One Earth Solar Farm

Draft Statement of Common Ground with Historic England

EN010159/APP/8.7.3

December 2025

Drawing Title:  
Figure 10.3 Designated Heritage Asset ZTV Mapping with 1km and 2km Radius

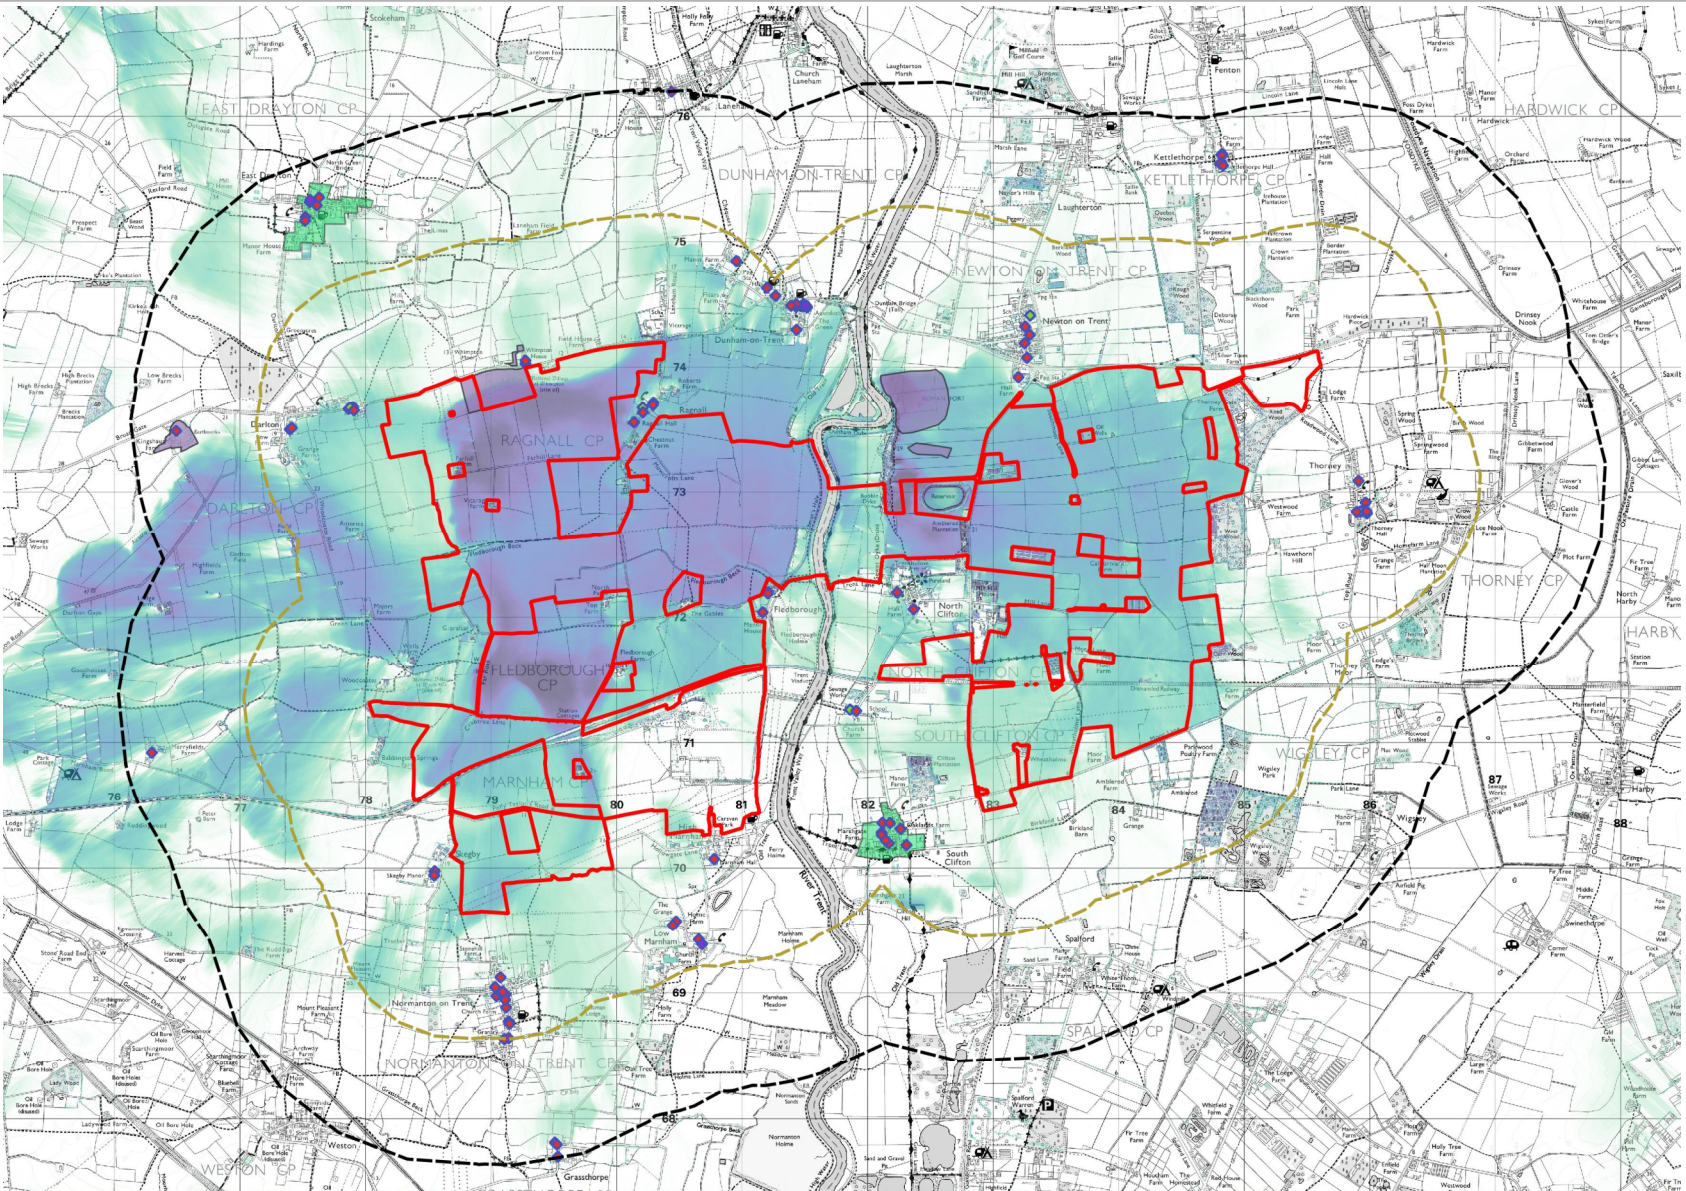
02-06	Impact on setting of built heritage assets	<p>Further understanding required on field to the north of North and South Clifton as viewed from Fledborough Viaduct.</p> <p>Further detail can be found in Historic England's Relevant Representation [RR-019, 190], as well as email correspondence</p>	<p>The understanding of Proposed Development in relation to North and South Clifton is supported by LVIA photomontages (Views 25a, Figure 11.13.7a, [AS-038]) and Zone of Theoretical Visibility (Figure 10.3 [APP-055]). The effect on heritage assets within North and South</p>	Agreed

in December 2024 – January 2025.	Clifton is provided in pages 51-53 and page 57 of ES Chapter 10 [APP-039]. There are no harmful effects identified to these assets.	
02-07	Mitigation	<p>Historic England have requested for mitigation to be provided at western substation (Gibraltar Farm) and consideration of associated impacts, i.e. lighting.</p> <p>Further detail can be found in Historic England's Relevant Representation [RR-019, 190], as well as email correspondence in December 2024 – January 2025.</p>	The mitigation for Gibraltar Farm has been clarified at 10.5.5 of ES Chapter 10 [APP-039], and the assessment has been provided at 10.6.65 - 67. The mitigation provided is considered to be proportionate to the very low value of this asset. And this location is considered preferable to others, as per the response to comment 02-02 above.	Agreed
02-08	Impact on setting of heritage assets	<p>Historic England raised concerns on the proximity of the solar panels to the south of Whimpton Moor SM. Larger buffer suggested, "possibly by removing the triangular area of panels to the brown line indicated on the masterplan".</p> <p>Further detail can be found in Historic England's Statutory Consultation Response (reference can be provided upon</p>	Further detail can be found in Table 10.5 of ES Chapter 10: Cultural Heritage [APP-039]. The effect on Whimpton Moor Scheduled Monument has been assessed in ES Chapter 10 at 10.6.39 – 41 [APP-039]. Whilst there would be harm to the significance of Whimpton Moor from Development in its setting, this would be less than substantial in the middle of the spectrum (minor-moderate adverse	Agreed
